Mr Anthony Witherdin, Director, Key Sites  
Assessments  
NSW Department of Planning and Environment  
4 Parramatta Square, 12 Darcy Street  
Parramatta NSW 2124

**Your Reference** SSD-14378717

## City of Parramatta Council submission to Response to Request for Further Information (December 2022) for the Telopea Concept Plan and Stage 1A State Significant Development Application

Figure 18 Proposed Height of Buildings – Stage 1A

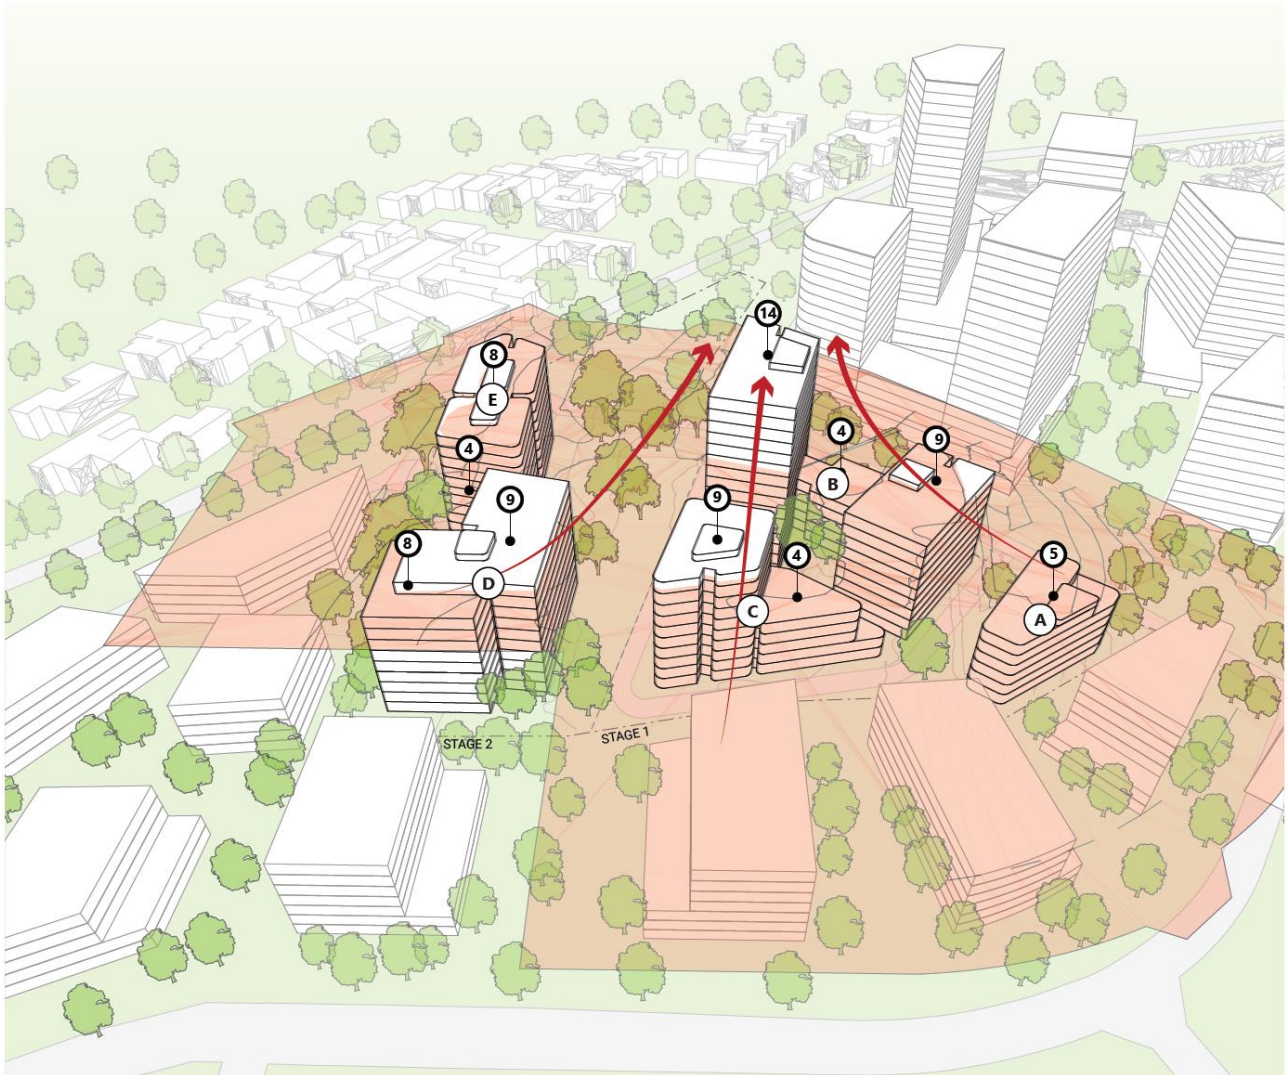
- **Clause 4.6 of Parramatta LEP 2011 – Variation to Height** Council does not support the proposal for The Core nor Stage 1A to significantly vary the maximum height contained in the Parramatta LEP 2011. The latest plans indicate height increase variations range between 11% to 79% for Stage 1A and 3% to 79% for The Core, which are significant non-compliances. Council does not believe adequate justification has been provided to support the extent of variation being sought. Furthermore, Council does not support the overshadowing impact to Telopea Primary School and Sturt Park as a result of the height increases.
